19 July 2013

**Re: Abercrombie Precinct Redevelopment  
Section 75W submission - Architectural Design Statement**

**Table 1 – Proposed modifications**

Project number: **6423** Drawing number: **A2201** Revision: **F**

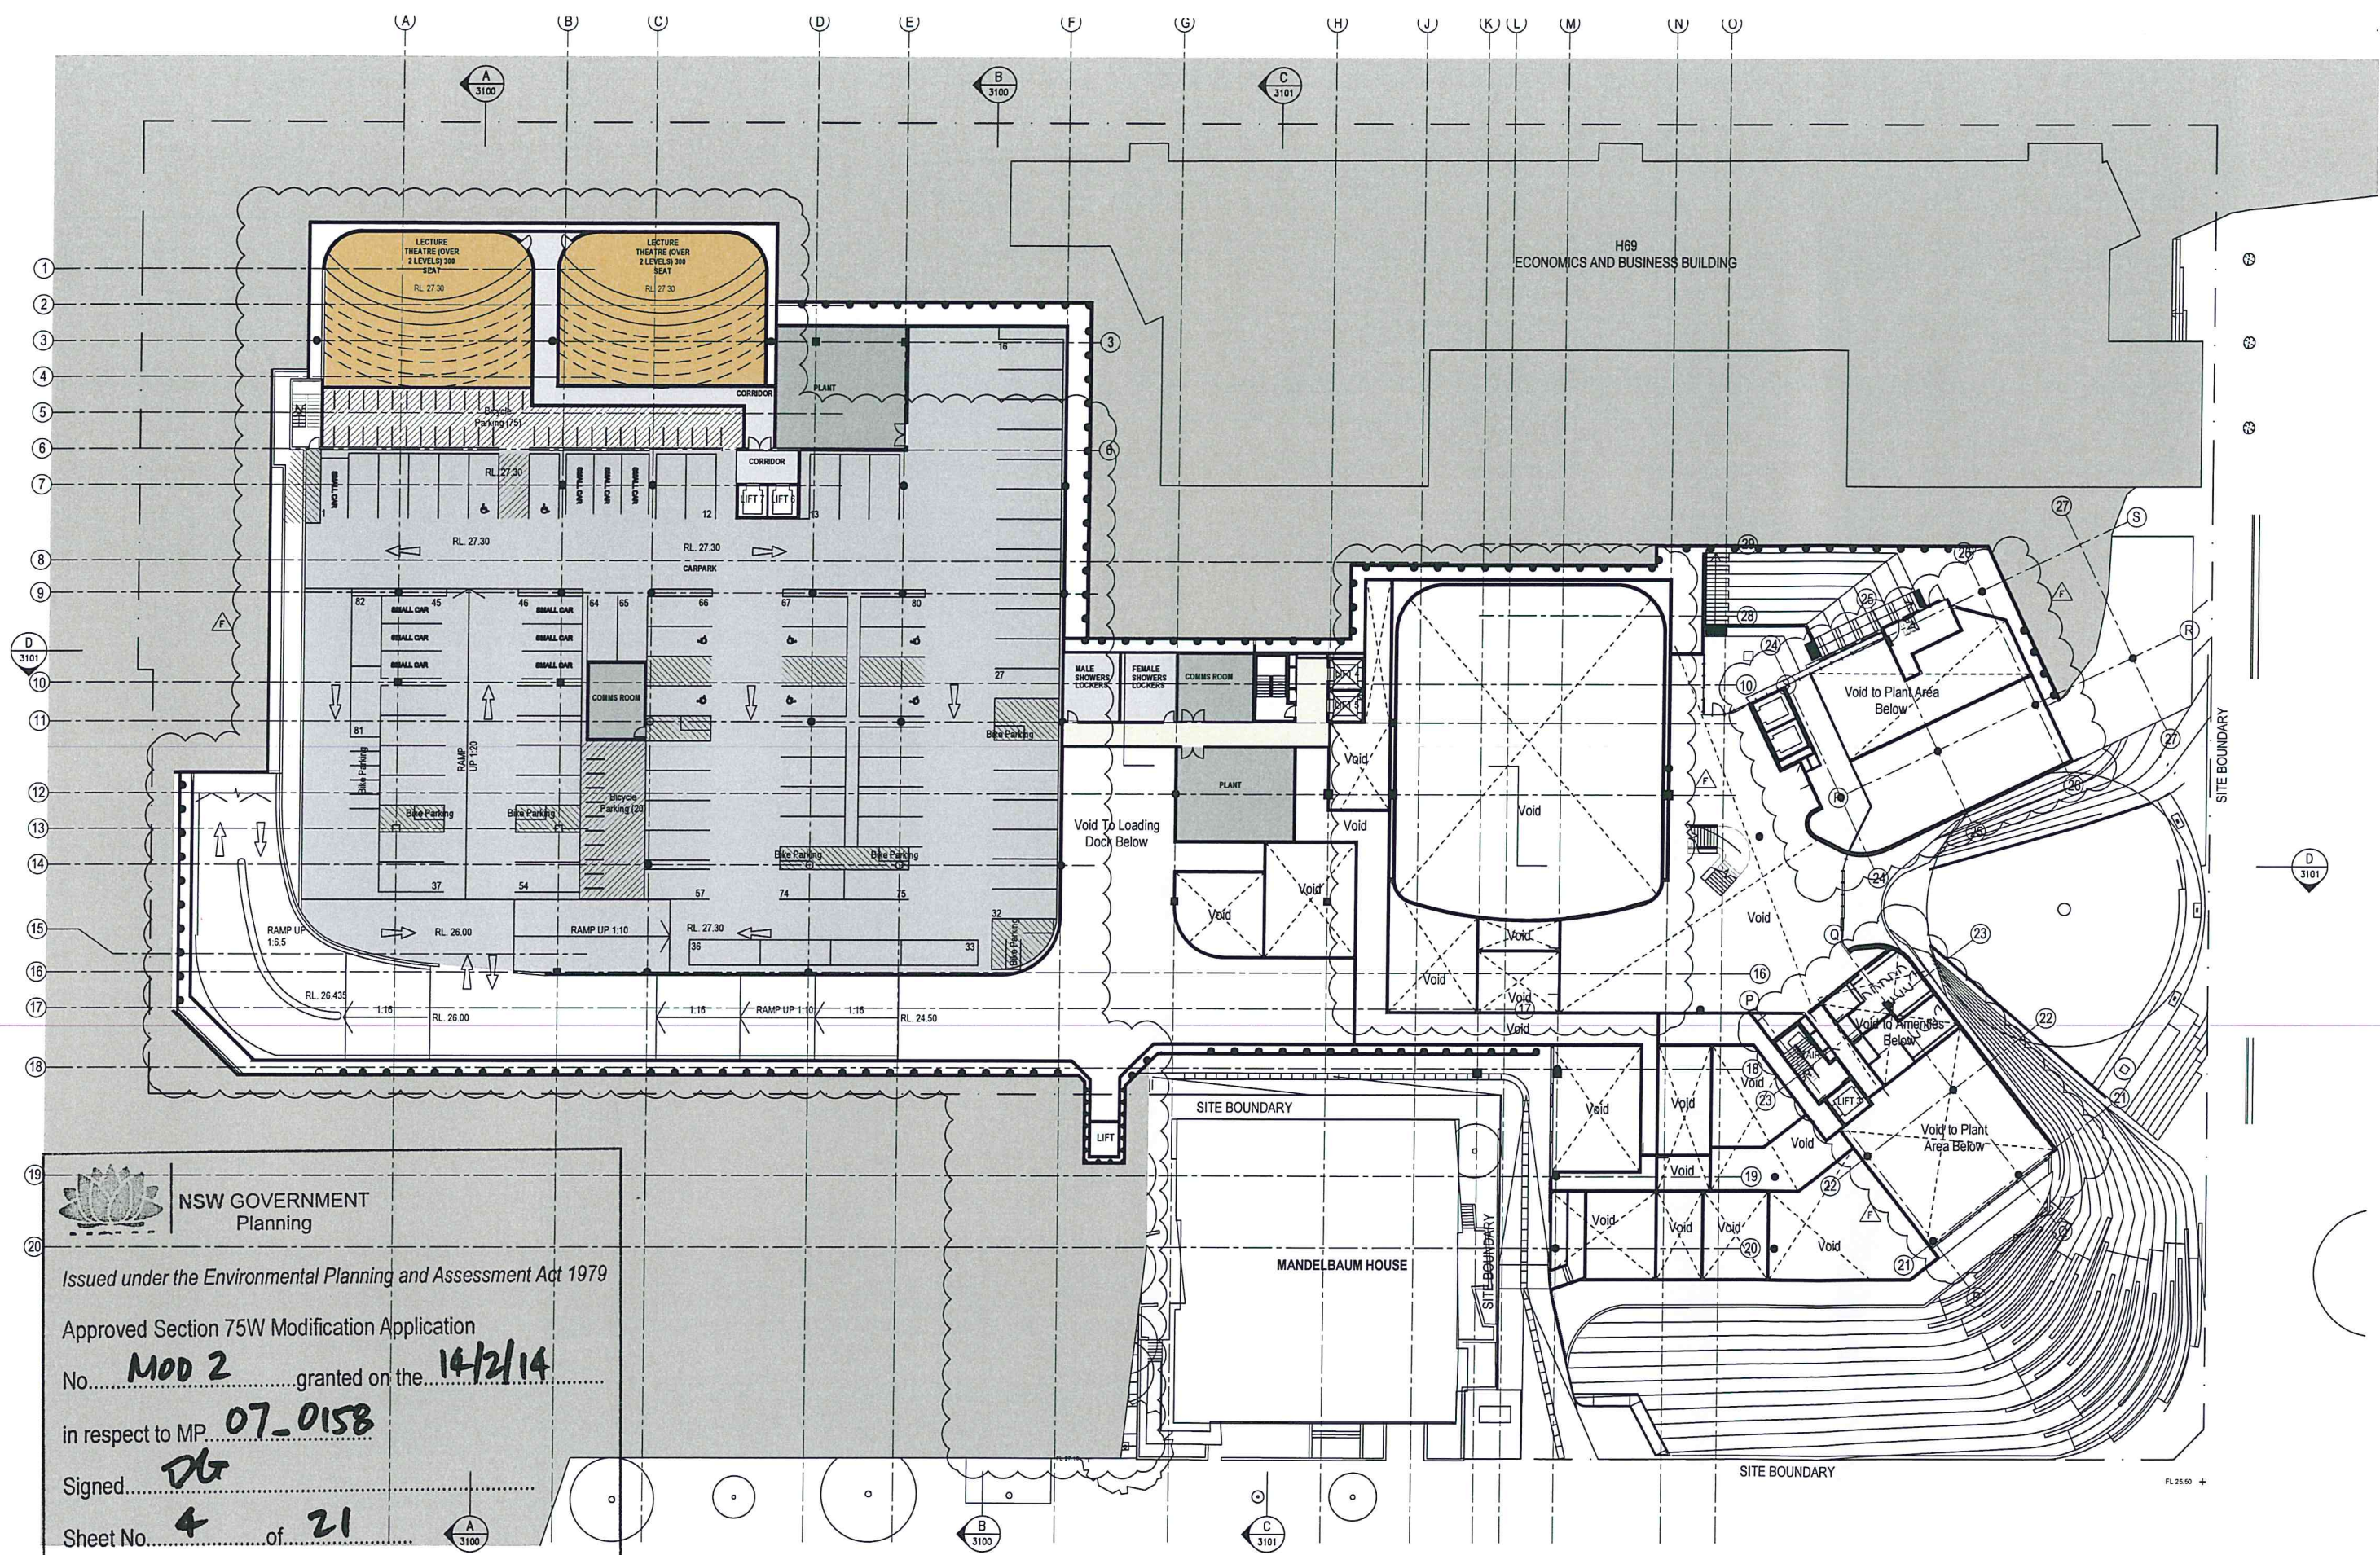
▪ External works detail added.	
	▪ Main entry modified.	
	▪ Stair No. 3 modified.	
Upper Car Park Level	▪ Kerb and site edge detail added to south east corner.	A2201 Issue E

▪ Vehicle entry/exit ramp to Abercrombie Street deleted.	
	▪ Re-orientated vehicle ramp added south and west of Block G.	
	▪ 1 X 550 Seat Theatre deleted in south west corner

Level	Description of proposed modification	Drawing No.
	<ul style="list-style-type: none"> <li>▪ Bicycle parking added.</li> <li>▪ 2 X 300 Seat Theatres added below Blocks H &amp; J.</li> <li>▪ Modified extent of excavation to north west corner of site below Blocks H &amp; J.</li> <li>▪ Car park area increased to accommodate deleted lower parking level.</li> <li>▪ Showers/Lockers added.</li> <li>▪ Stair No. 10 relocated.</li> <li>▪ 2 X 300 Seat Theatres deleted.</li> <li>▪ 1 X 550 Seat Theatre added in lieu.</li> <li>▪ Stair No. 9 relocated.</li> <li>▪ Courtyard detail and access added from level above.</li> <li>▪ Orientation of Block A &amp; Block B modified.</li> <li>▪ Entry modified.</li> <li>▪ Stair No. 3 modified.</li> </ul>	
Ground Floor Level	<ul style="list-style-type: none"> <li>▪ Block C relocated.</li> <li>▪ Block D ICT Service Centre layout modified</li> <li>▪ Block D Stair No. 20 added.</li> <li>▪ Stair No. 4 modified.</li> <li>▪ External form of Block E Case study Room modified.</li> <li>▪ Location of Block E modified to align with south edge of Blocks D &amp; F.</li> <li>▪ Block G 550 Seat Theatre deleted.</li> <li>▪ Block G 100 Seat Case Study Room added in lieu.</li> <li>▪ Block G Computer Lab added.</li> <li>▪ Vehicle entry/exit ramp to Lower Ground added to west side of Block G.</li> <li>▪ Block H 100 Seat Case Study Room relocated to Block K</li> <li>▪ Blocks J &amp; K Seminar rooms relocated.</li> <li>▪ Sub-Station relocated to Level 1.</li> <li>▪ Blocks H &amp; J 2 X 300 Seat Theatres added.</li> <li>▪ Block L relocated.</li> <li>▪ Stair No. 9 relocated.</li> <li>▪ Stair No. 8 modified.</li> <li>▪ Block K Seminar Rooms added.</li> <li>▪ H69 Economics and Business Building retained as operational during construction phase.</li> <li>▪ Orientation of Block A &amp; Block B modified.</li> <li>▪ Entry modified.</li> <li>▪ Stair No. 3 modified.</li> </ul>	A2202 Issue E

Drawing number
A2204

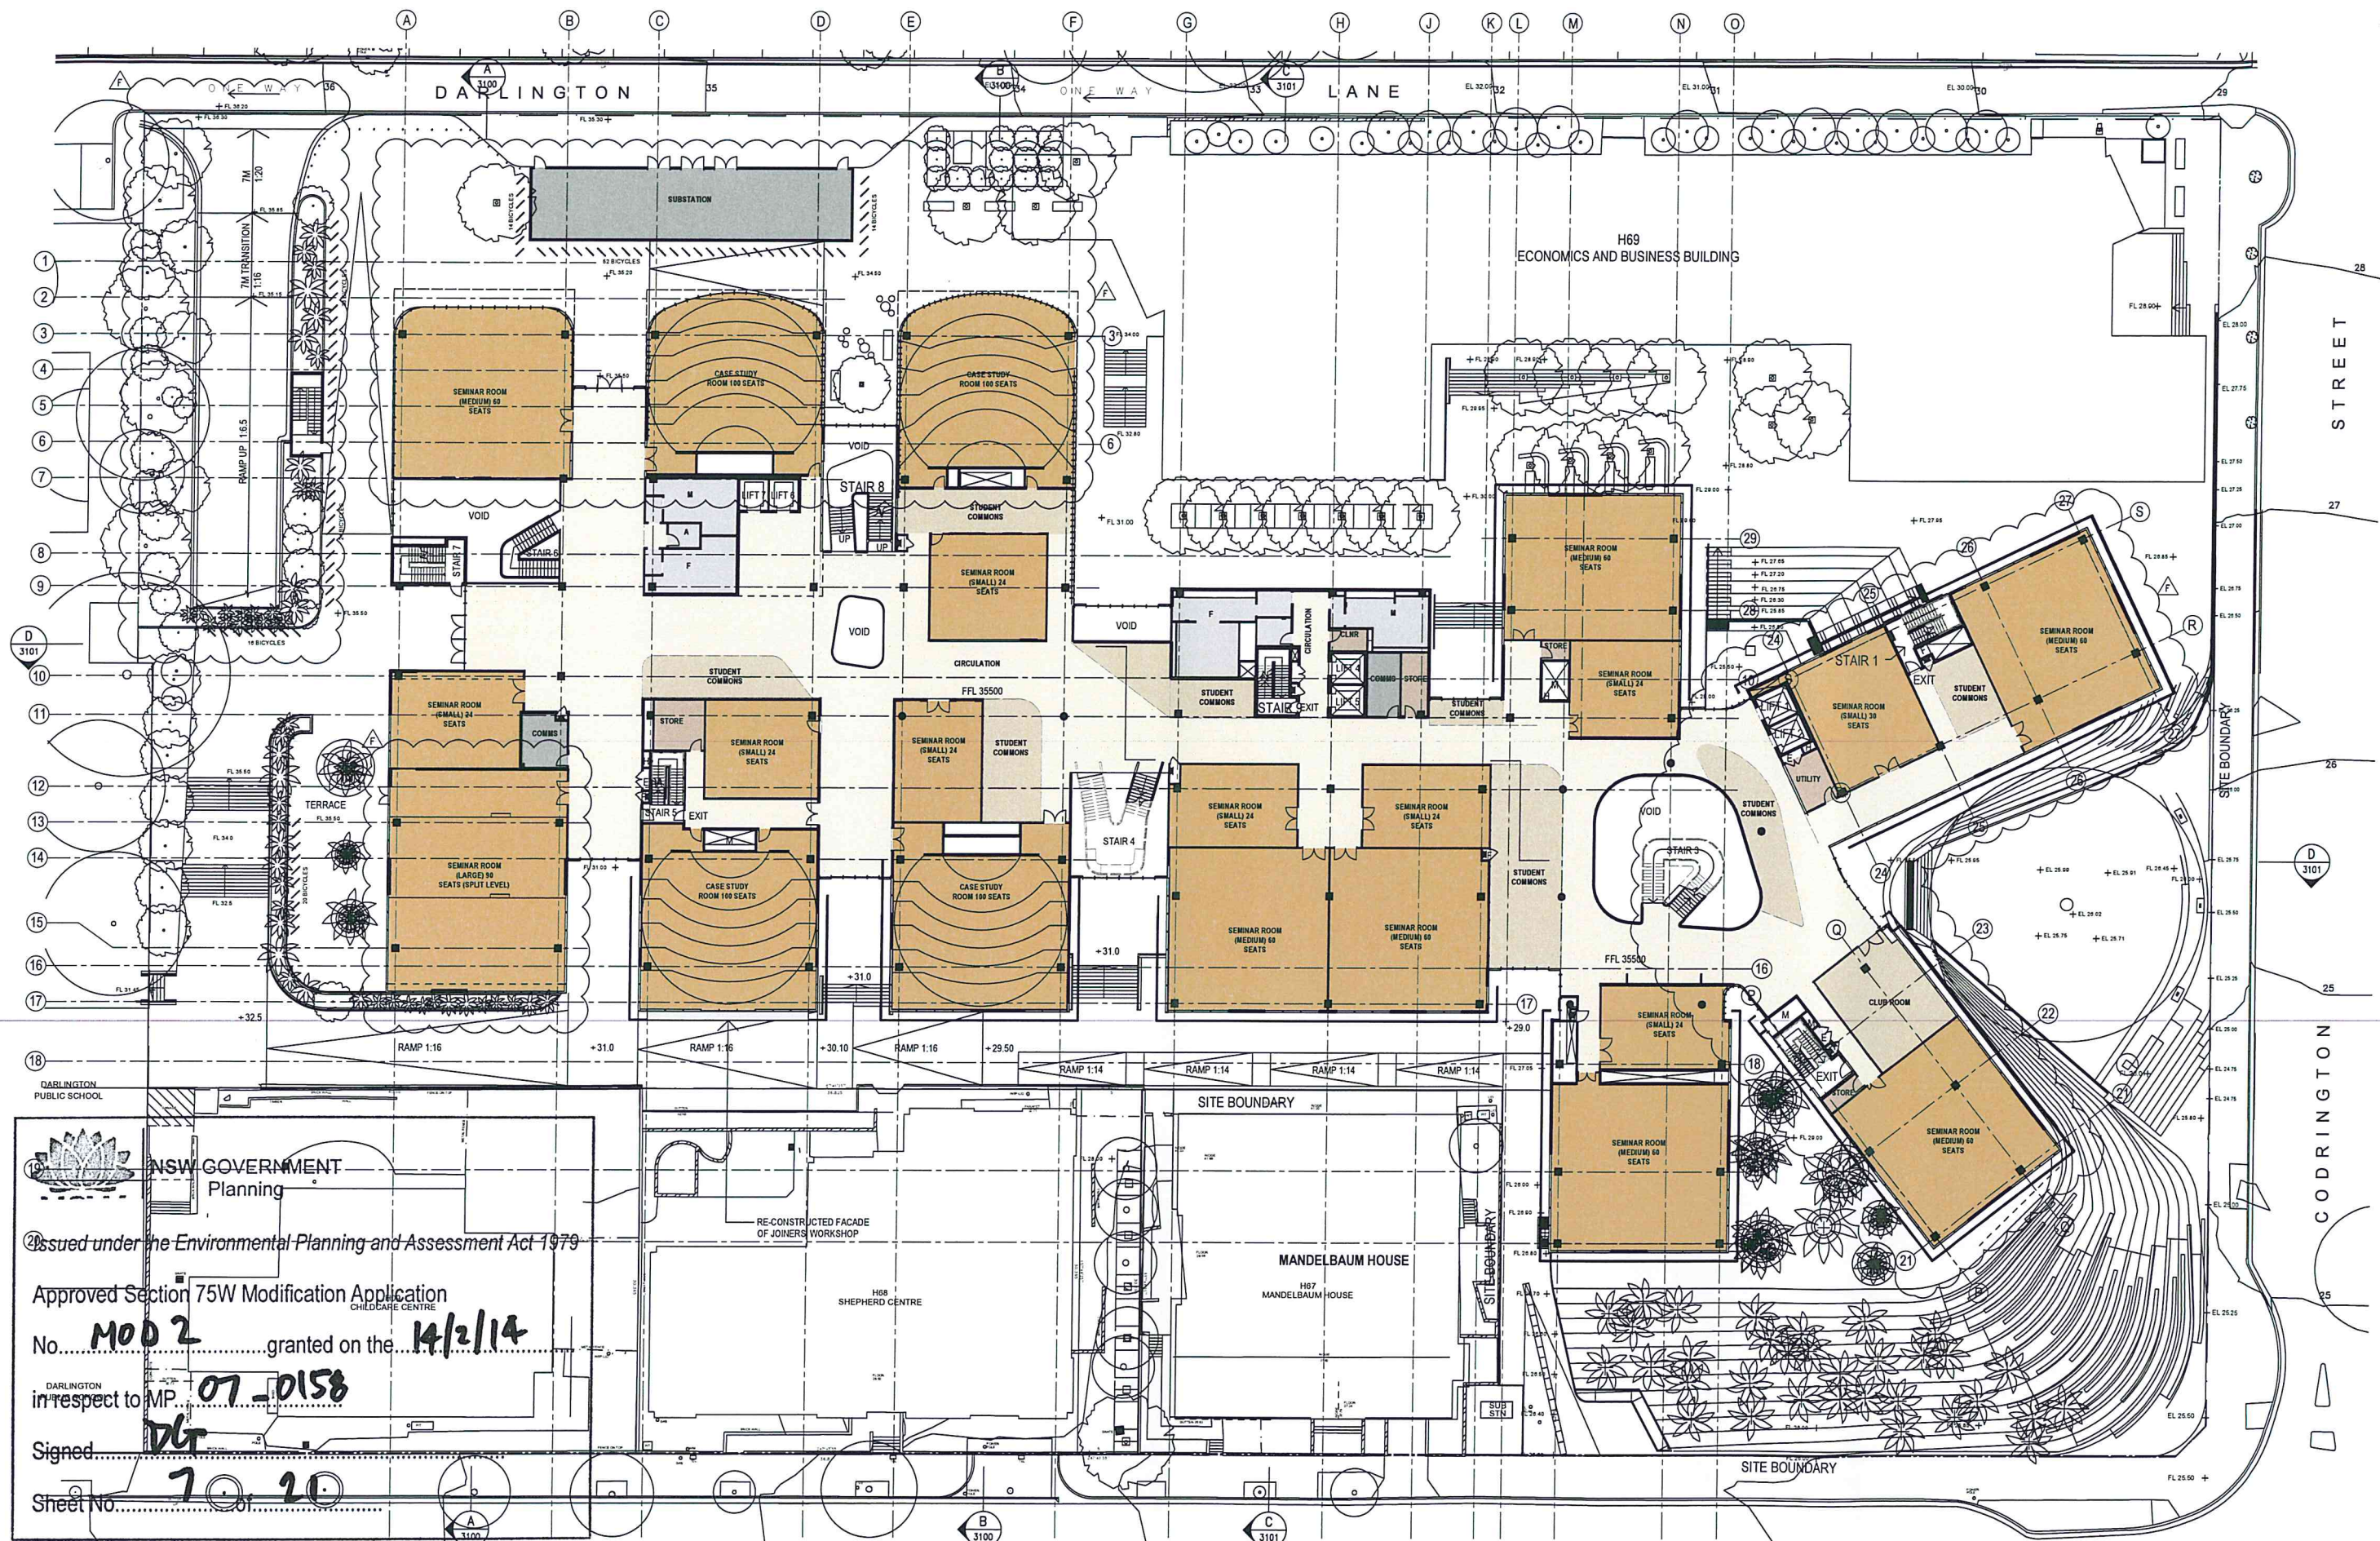
▪ Orientation of Block A & Block B modified.	
	▪ Stair No. 3 modified.	
Level 01	▪ Block C relocated.	A2204 Issue E
	▪ Block B Club Room added.	
	▪ Block D minor layout modification.

▪ Stair No. 4 modified.	
	▪ Block E 100 Seat Case Study Room modified to align with south edge of Blocks D & F.	
	▪ Block F Toilets and Lifts relocated to Block J.

▪ Block G 90 Seat Seminar Room added in lieu of 100 Seat Case Study Room.	
	▪ Vehicle Ramp entry/exit added south of Block H.	
	▪ Stair No. 6 modified.

▪ Sub-Station relocated from Ground level.	
	▪ Stair No. 8 modified.	
	▪ Stair No. 9 relocated.	
	▪ Block K Seminar relocated. 100 Seat Case Study Room added in lieu.

▪ Locations of Blocks H, J & K modified and aligned with adjacent Blocks.	
	▪ Block L relocated.	
	▪ H69 Economics and Business Building retained as operational during construction phase.

▪ Orientation of Block A & Block B modified.	
	▪ Stair No. 3 modified.
